Summer Lane, Wombwell

Highways Transport Note

AMA Project Number: 23498/HTN-001

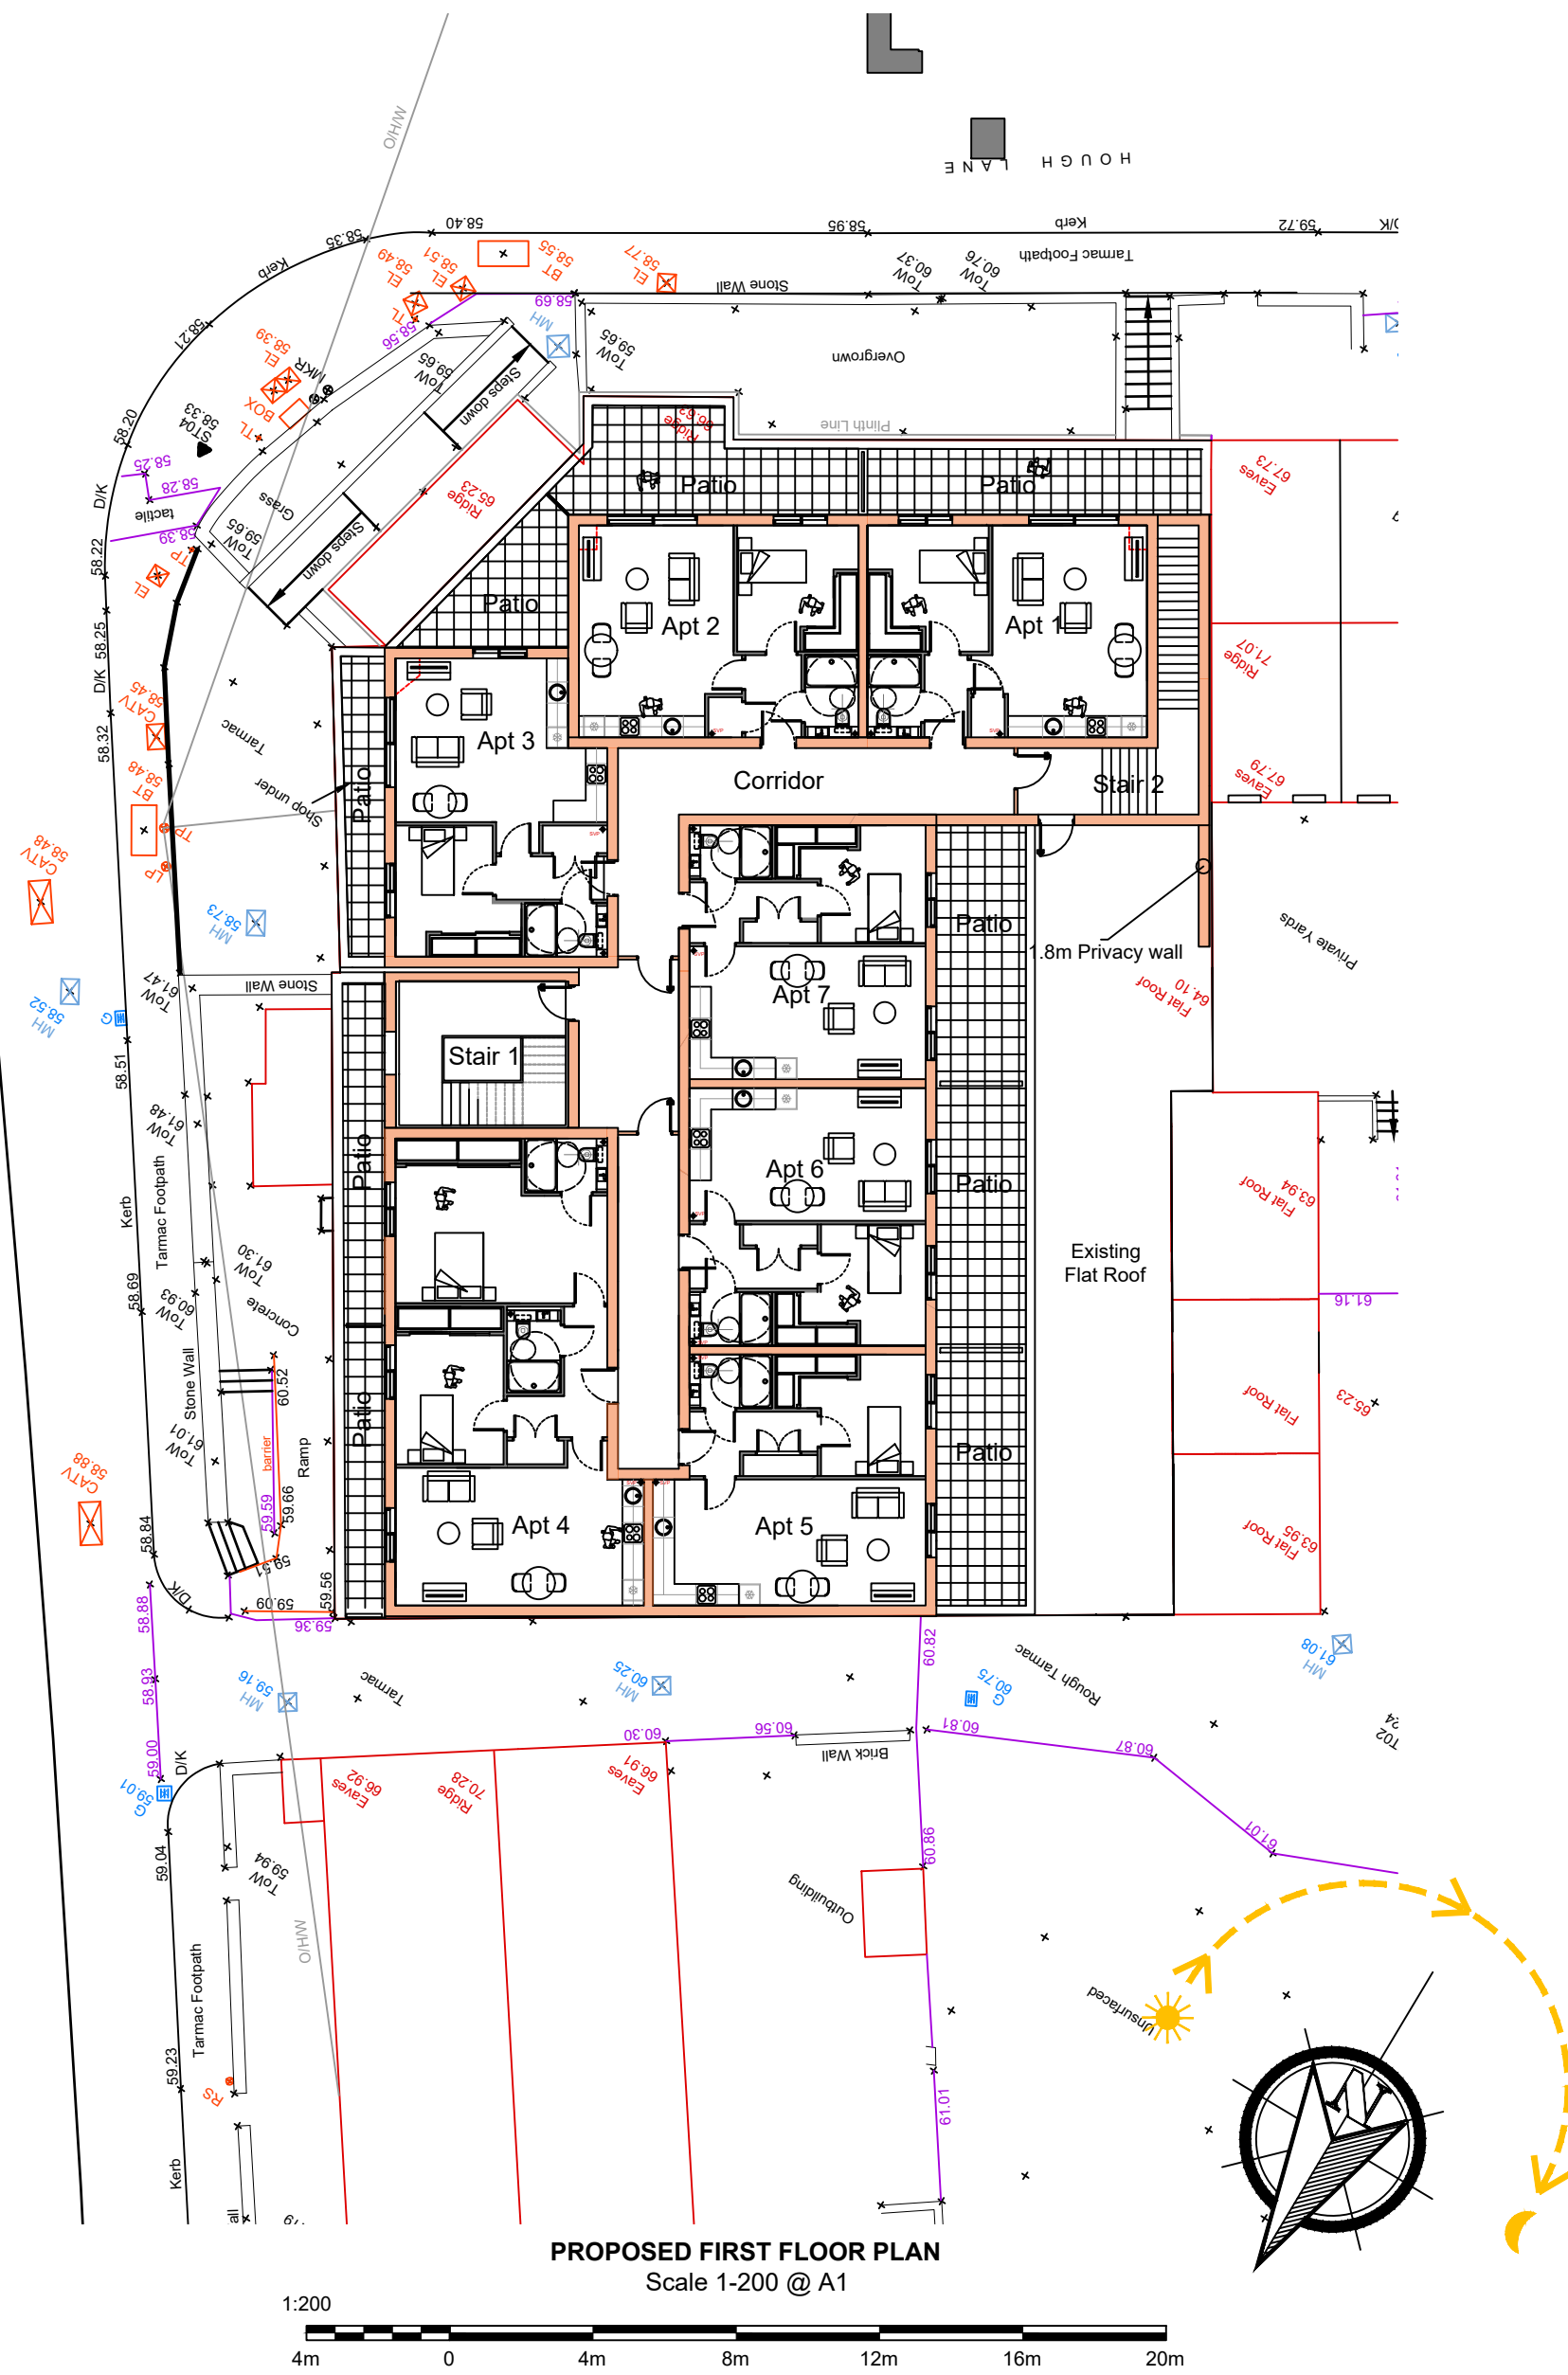
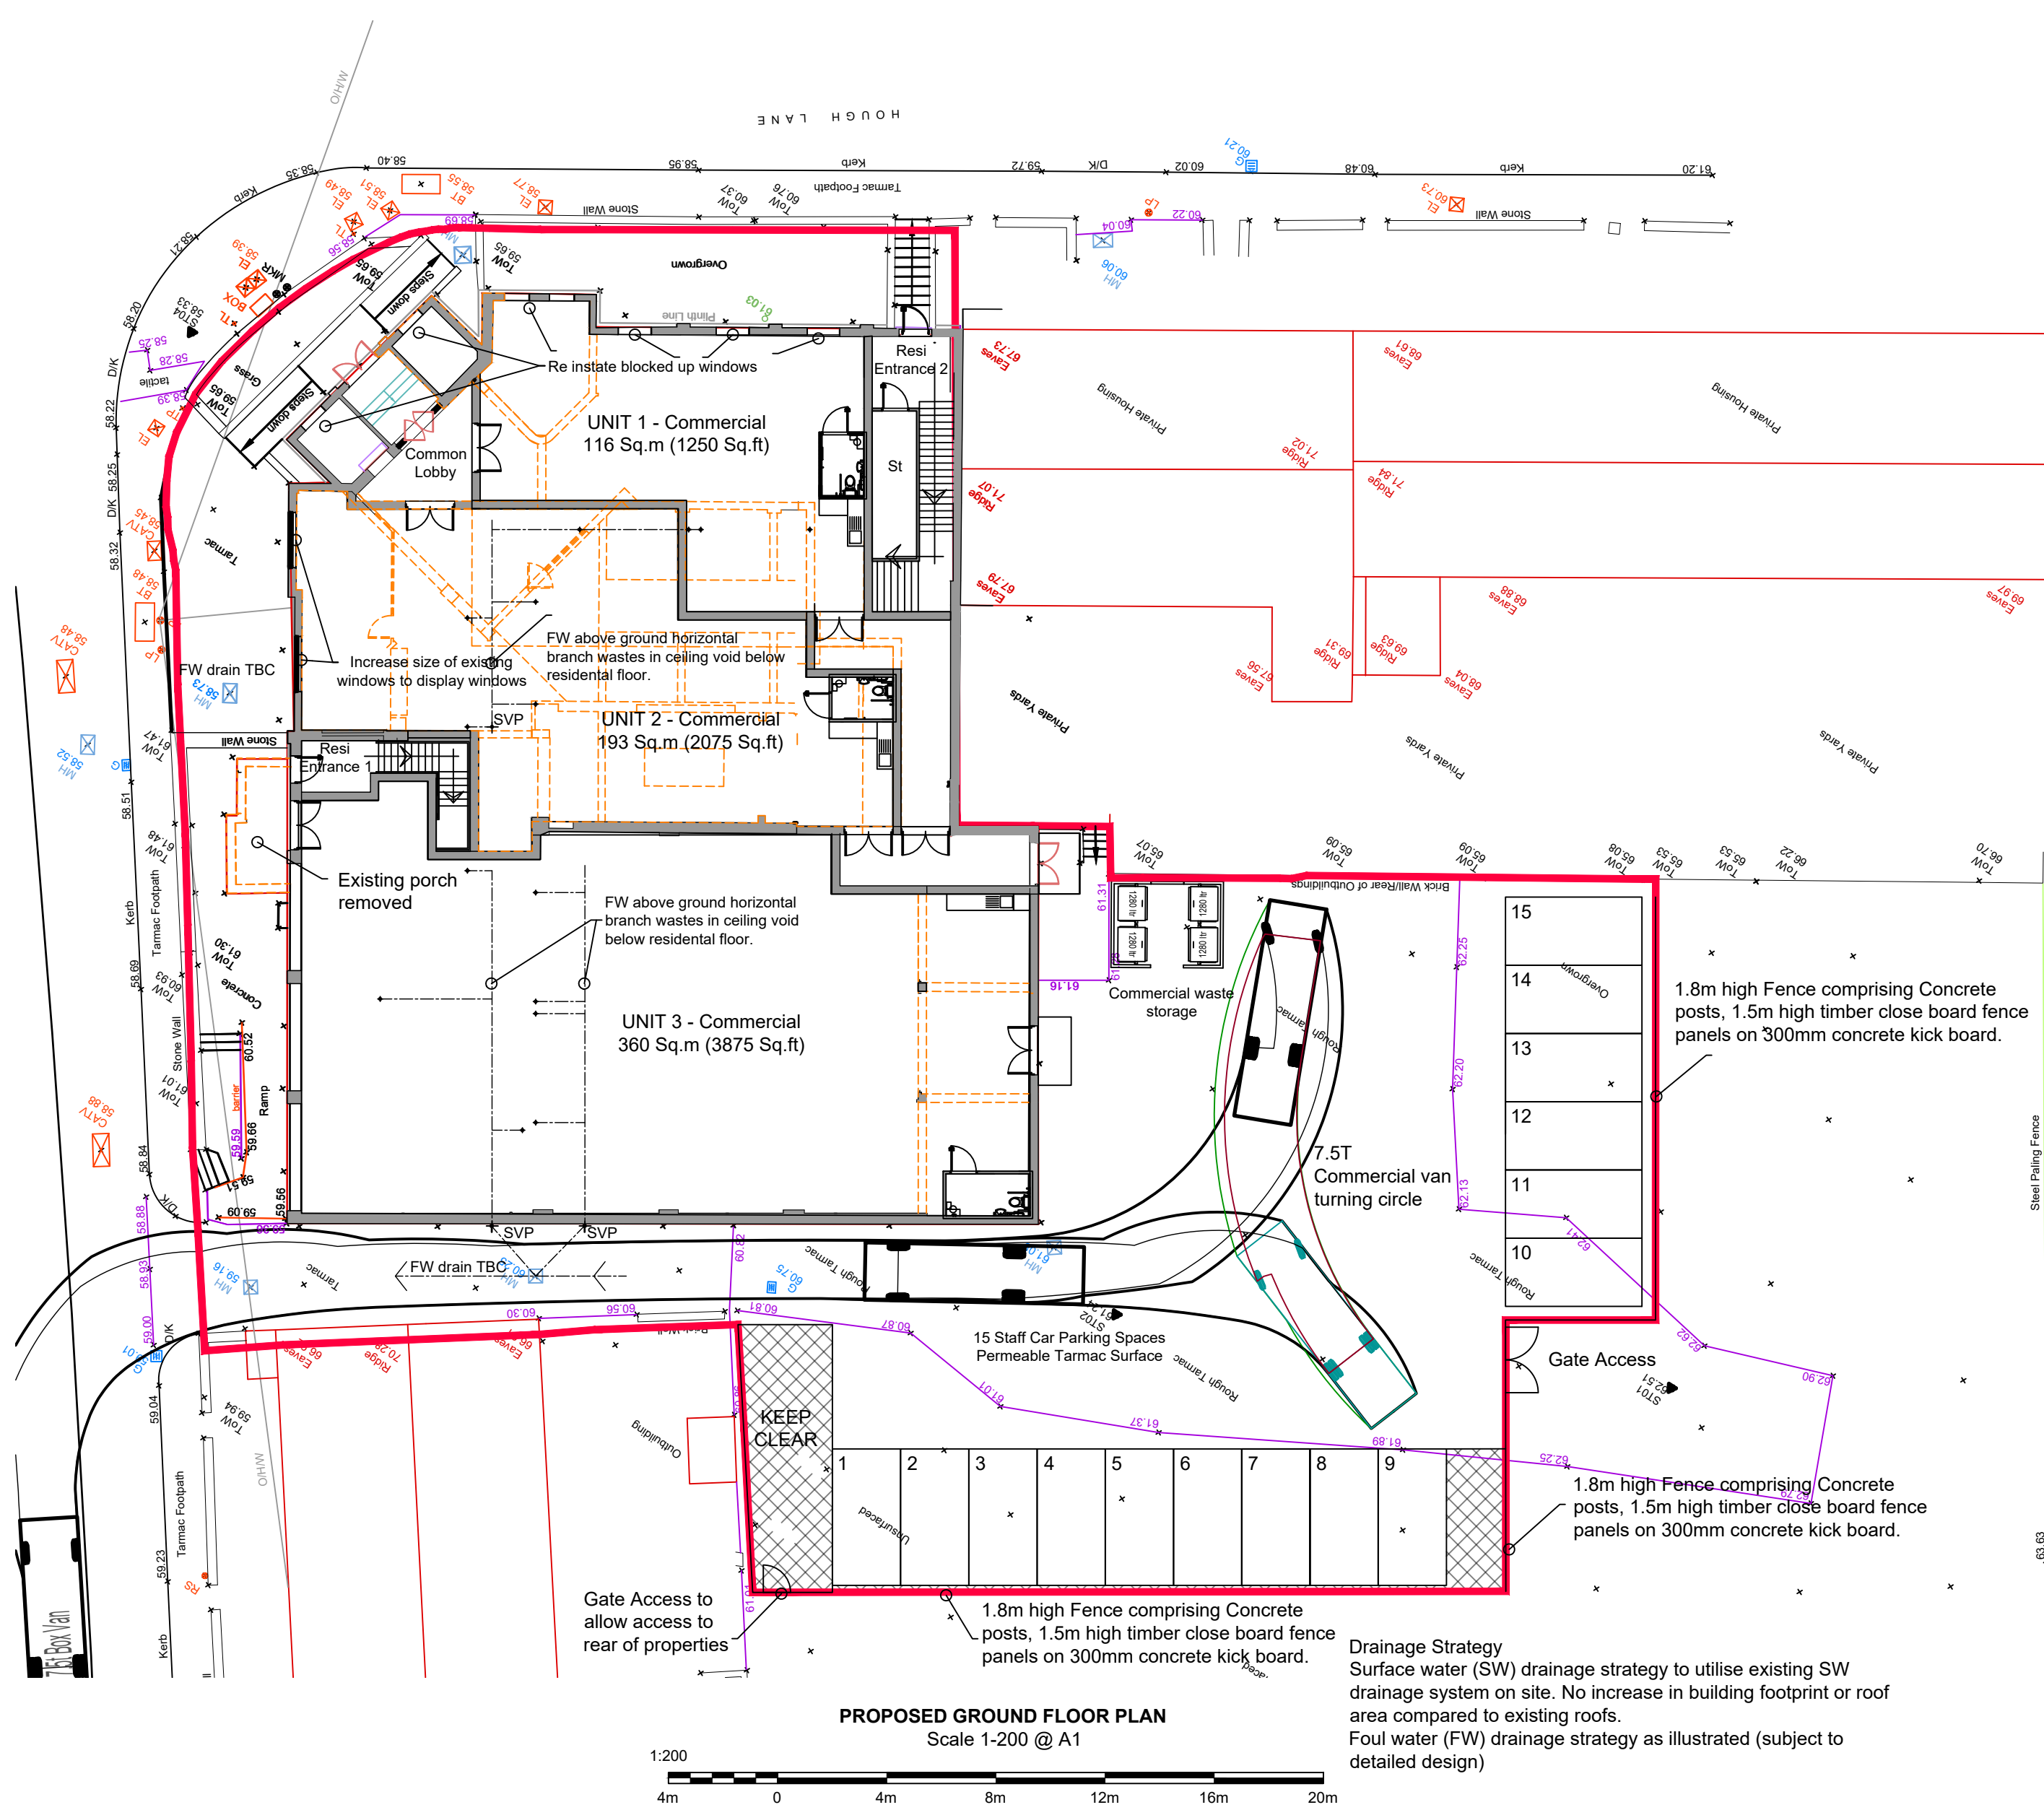
With regard to commercial waste, it is noted that the bin store is positioned within the site. Details should therefore be provided in terms of the proposed collection arrangements. Council refuse vehicles would not enter the private access; it should therefore be stated whether or not a private waste collection company is to be used. If so, the type and size of vehicle most likely to be used for collection should be stated. It should be demonstrated by swept path manoeuvres that the collection vehicle would be able to satisfactorily access and egress the site.

Refuse collection for the commercial use of the development is expected to be undertaken by council refuse vehicles and be undertaken from Summer Lane opposite the site frontage as per existing arrangements for residential properties along Summer Lane which are collected from the kerbside.

The process will involve a management team taking the refuse bins out to the roadside and left adjacent to the secure bin store for residential waste. Therefore, the commercial refuse bins will taken at the same time as the residential waste collection from Summer Lane.
